Our ref: Modification to the Concept Proposal for the Redevelopment of SCEGGS Darlinghurst (SSD-8993-Mod-3)

Subject: Response to Submissions

ATTACHMENT 1

LANDSCAPE MASTERPLAN

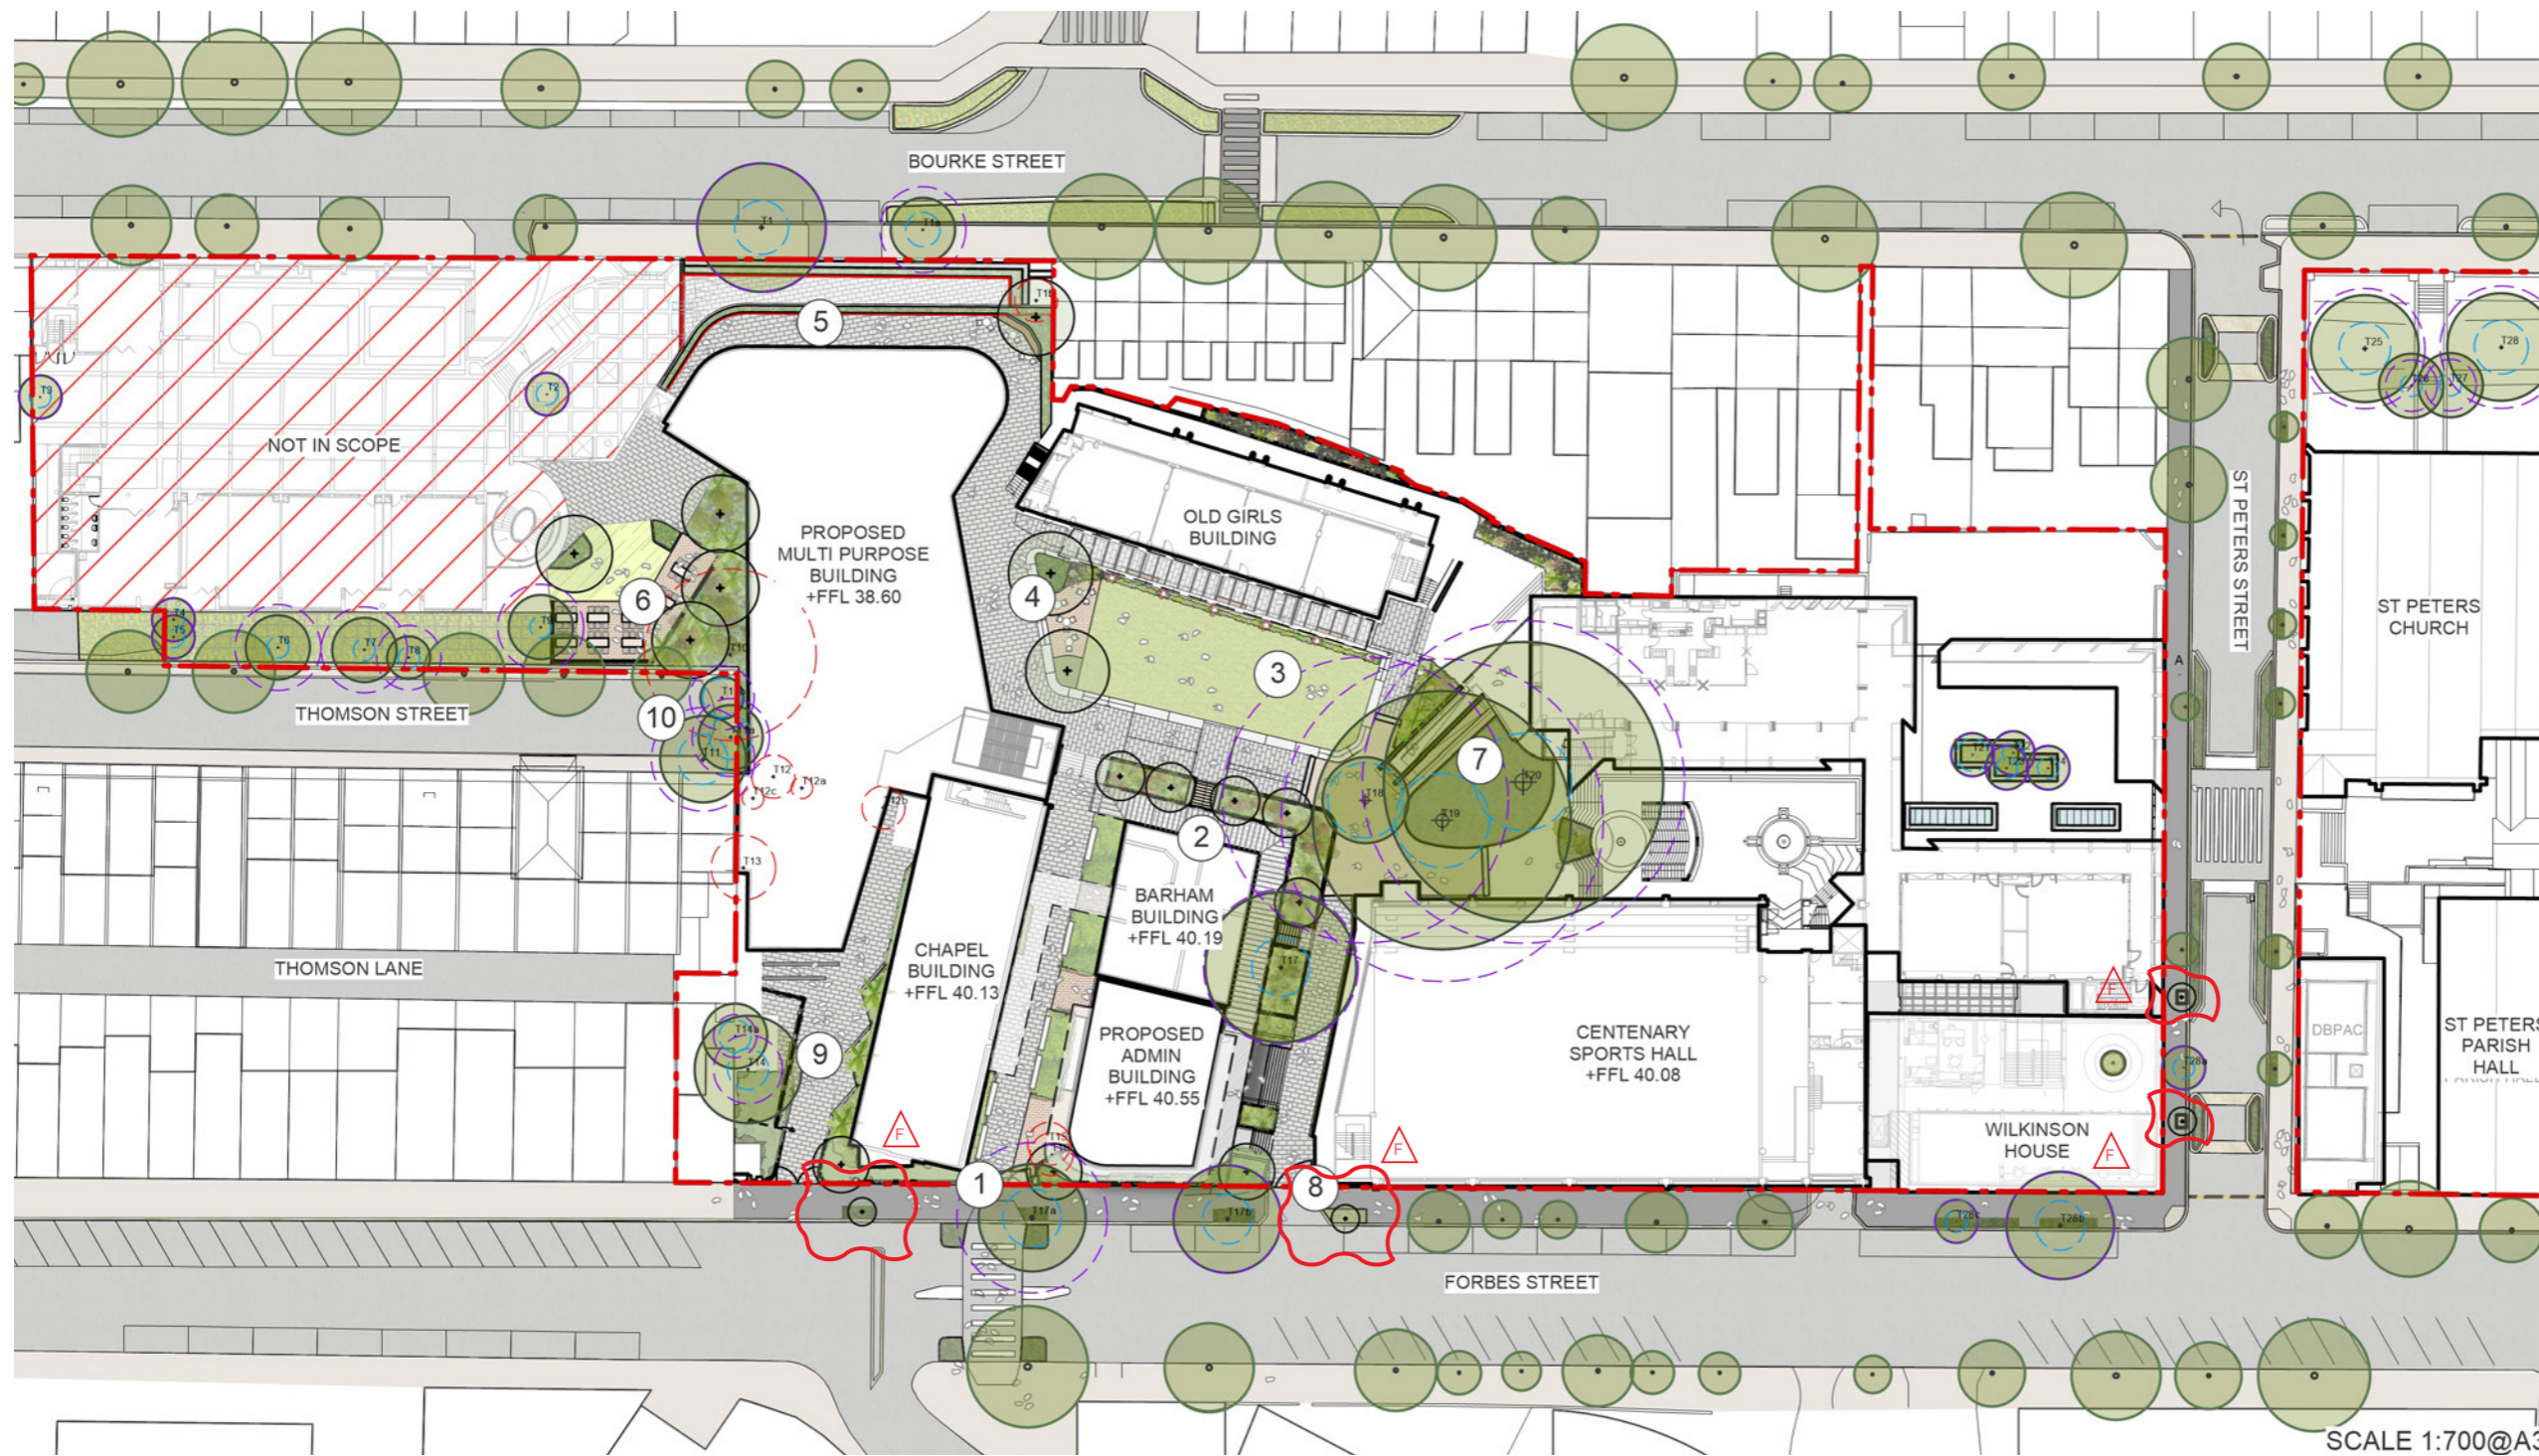
The Department recommends sub-clause (a)(i) of Condition B5 be modified to refer to the amended Landscape Masterplan submitted as part of the modification application.

- (a) landscape plans and details identifying the vegetation to be retained, removed or relocated, the location of replacement trees, and additional landscaping. The plans and details must:
 - (i) be generally in accordance with the Landscape Masterplan Rev ~~DE~~^{DE} prepared by Context and dated September ~~2019~~²⁰²¹ submitted with ~~the R+~~^{the R+}SSSD-8993-Mod-3;
